Consultation Response from: KC Environmental Health (Pollution & Noise Control)

2024/92512 - Land at Whitehall Road West, Birkenshaw, BD11 2LS

Discharge of details reserved by conditions 5 (internal roads), 6 (right turn lane), 8 (materials), 13 (ecological enhancement), 14 (coal mining legacy), 17 (temporary drainage), 18 (temporary waste arrangements), 19 (noise assessment), 20 (phase I study), 25 (air quality) and 27 (Construction Environmental Management Plan) of previous permission 2020/92802 for erection of 10 dwellings with associated infrastructure

Note – These comments relate to Condition 19 (Noise Assessment) ONLY

Fig 4A: Predicted LAeq,T Cumulative Daytime

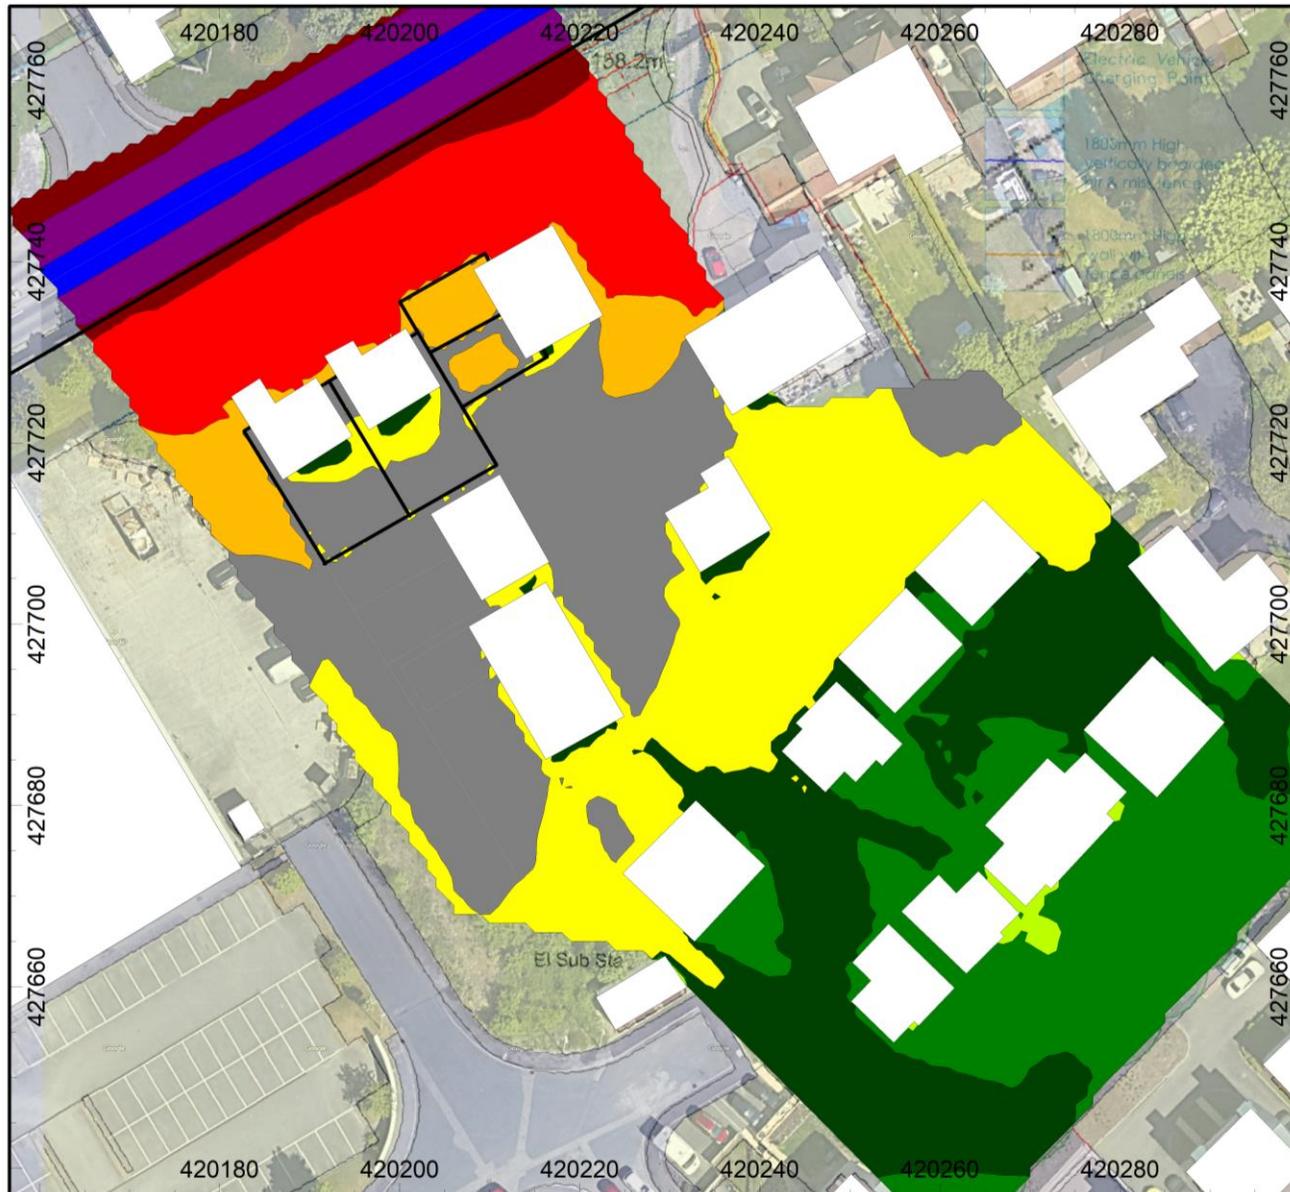
Modelling has been used to predict the levels of noise as shown in appendix 4 and in order to meet with both the daytime and nighttime requirements of BS8233, mitigation measures are necessary. Based upon reasonable construction assumptions, para 9.1.2 gives a specification for the glazing to both ground floor and first floor facades as shown in appendix 5 and table 6 shows it will meet with the internal requirements of BS8233. The external amenity areas show elevated noise levels and section 9.2 specifies mitigation measures. Para 9.2.2 states fencing up to 4.5m in height would be required to ensure plot 23 meets with the desirable level for external amenity and it is agreed that this would not be reasonable. BS8233 does state that these guideline values are not achievable in all circumstances and so this is accepted. As such, a recommendation is made for strategically located 2.8m high barriers to be installed as per appendix 6.
